From: Amanda Scholes on behalf of Planning.Responses
Sent: 22 February 2021 09:53
To: Planning Scanning
Subject: FW: BR/307/20/PL - Butlins kiosk - CDC ECOLOGY COMMENTS

I just wanted get back to you with comments regarding the above planning application. Whilst we do not have concerns regarding the application, due to the proximity of the site to the Lidsey Rife Biodiversity Opportunity Area we would like to see a bat sensitive lighting scheme implemented and also the inclusion of bat/sparrow boxes within/on the new structure.

REV	DATE	DESCRIPTION	BY	CHKD
A	15/12/20	Initial Issue	TB	KO
B	18/02/21	Vehicle Routes/Road Markings/Signage Amendments	TB	EO
C	23/02/21	Minor Amendments	TB	EO

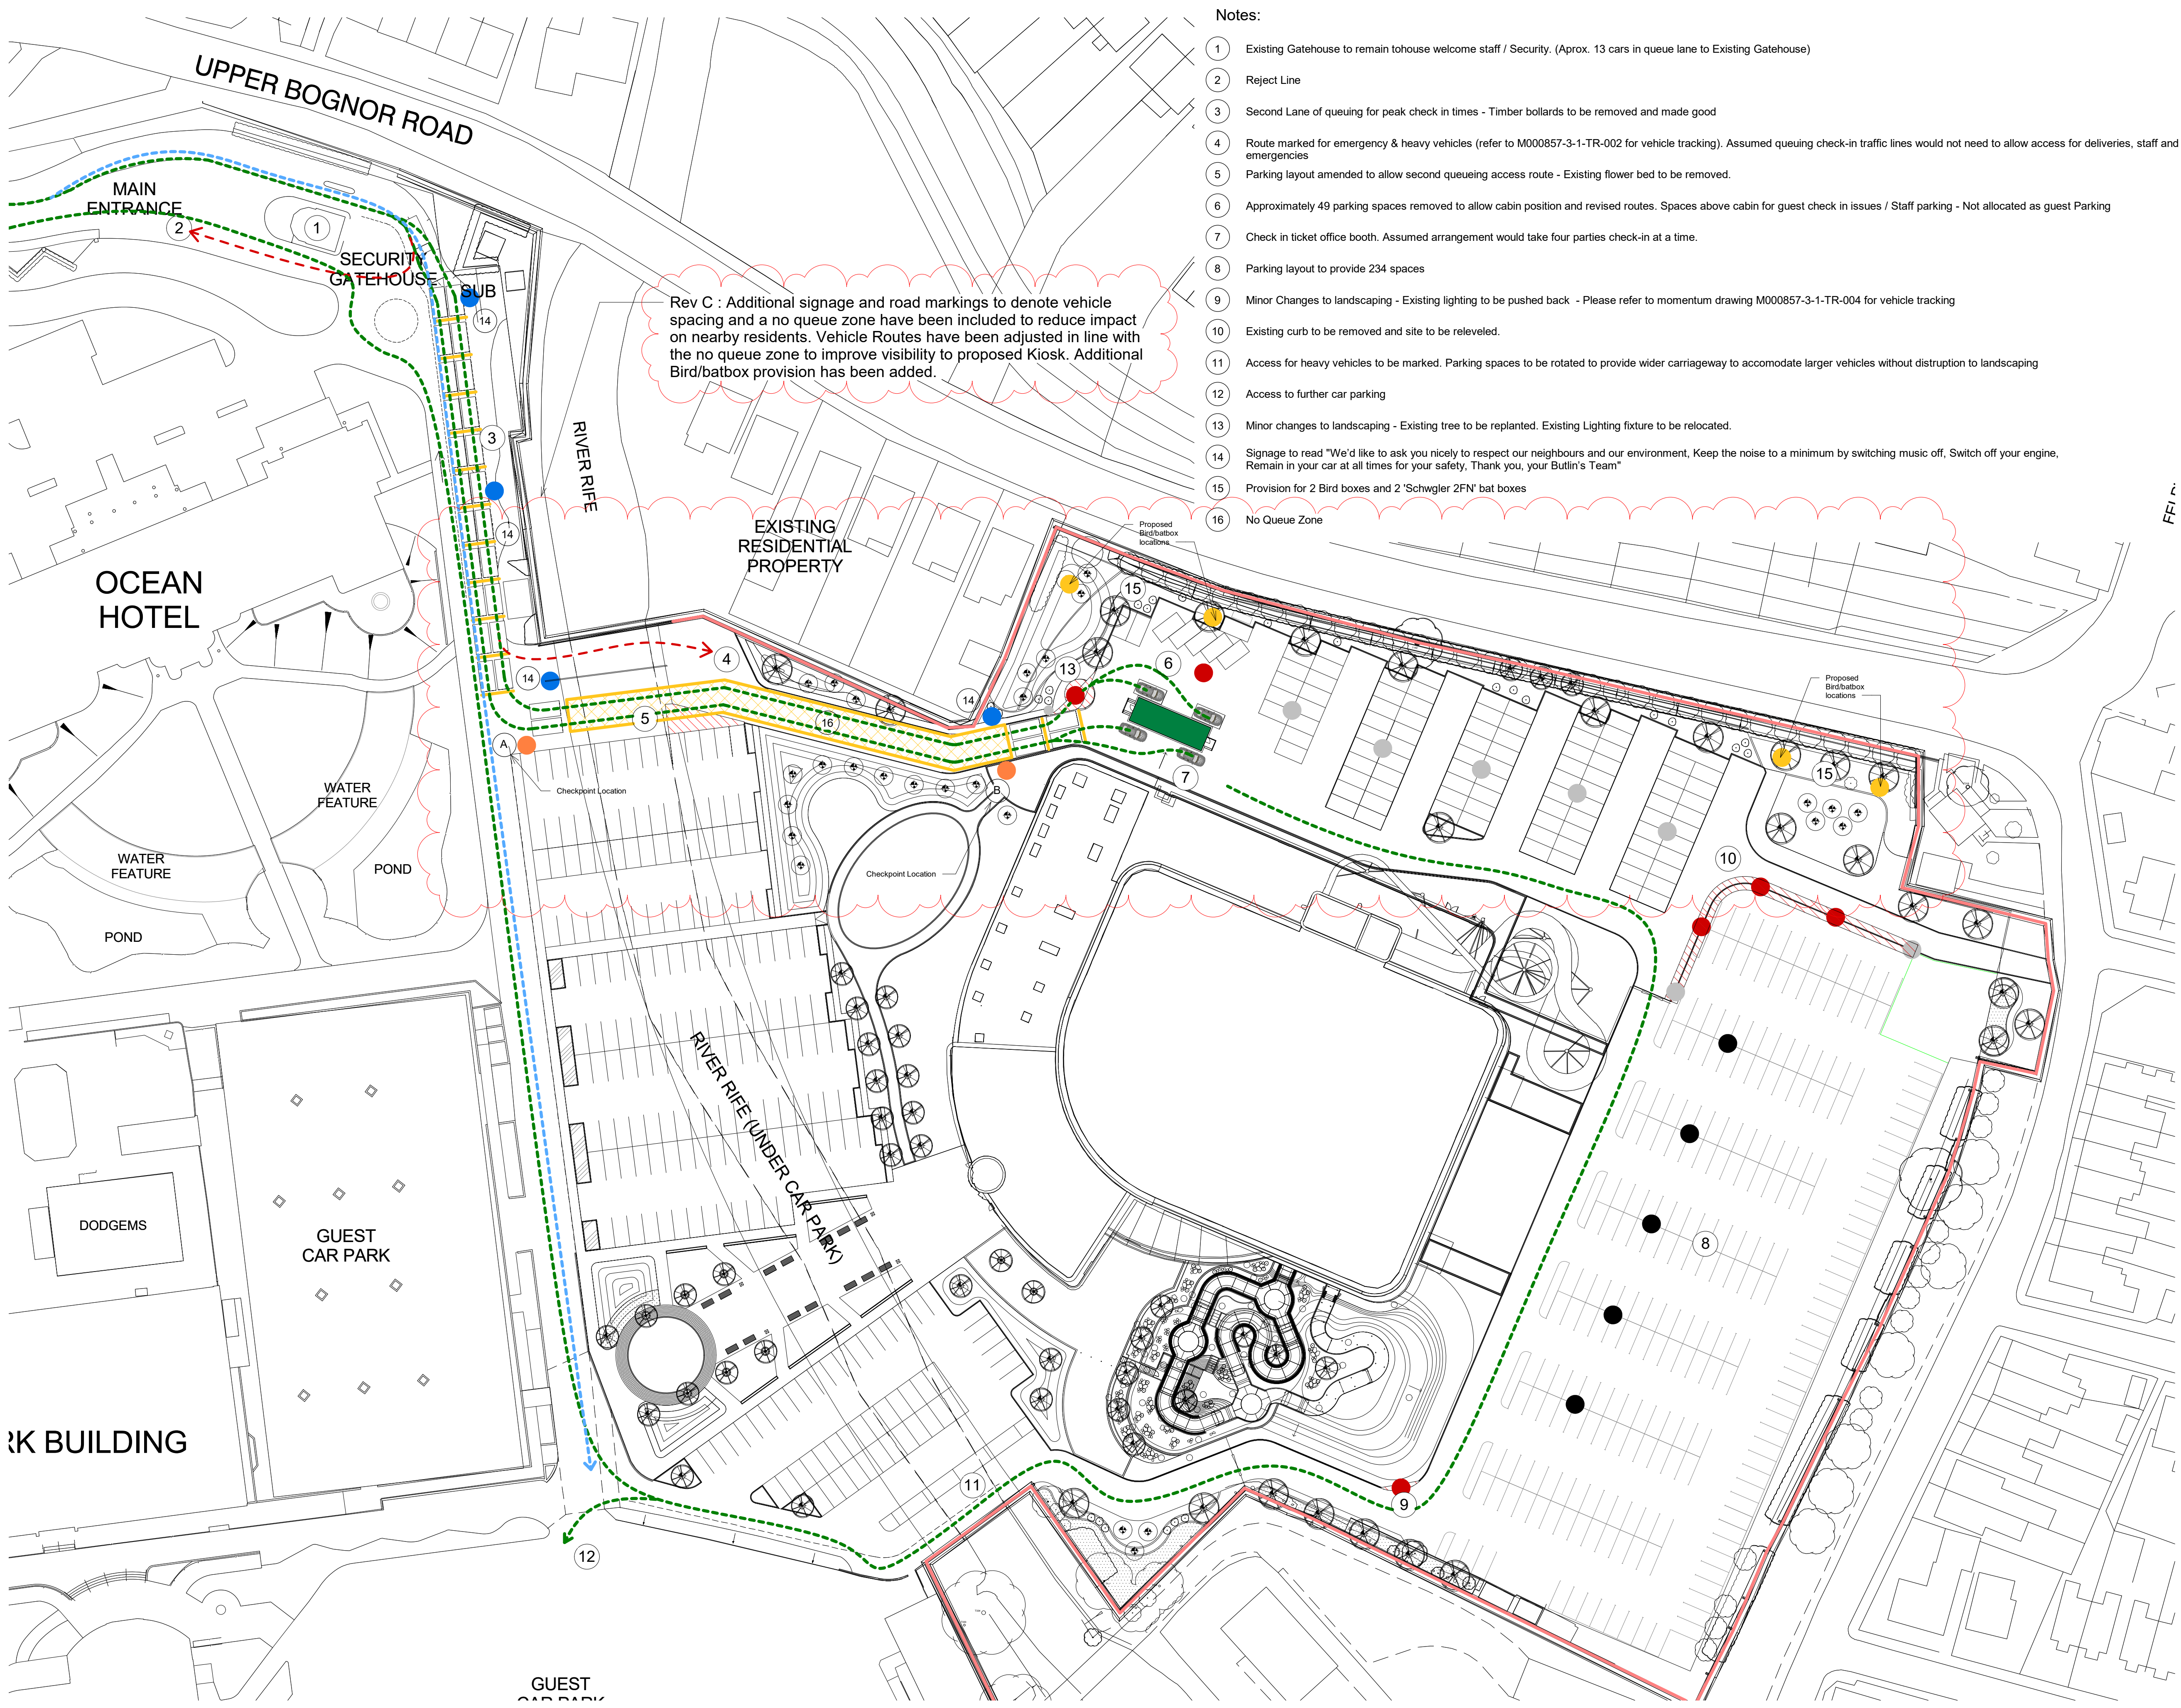
I think the lighting has been addressed, if there is not going to be any additional lighting. That is the lighting scheme, if you like.

In terms of the bird and bat boxes, these are needed to show net gain but I accept the boundary vegetation would be preferable and so can accept that.

- *Our submitted plans show that there is no new car park lighting, in fact the red dots on plan WOO/MPN/BOG/DR/A/0010A show 2 existing lighting columns in the vicinity of the proposed new kiosk being moved further away from the rife. The only changes to the car park lighting are movements of existing columns/fittings. On that basis there is not any new lighting to detail.*
- *The proposal is for a small "flat pack" sectional building it is also only single storey – which seems a hardly appropriate location for bird or bat boxes. Boxes were installed on site as part of the pool scheme, is it really necessary for more as part of such a small scale scheme? If this really is important we can install a couple more of similar to those used for the pool but putting these in boundary locations seems preferable to on the building itself.*
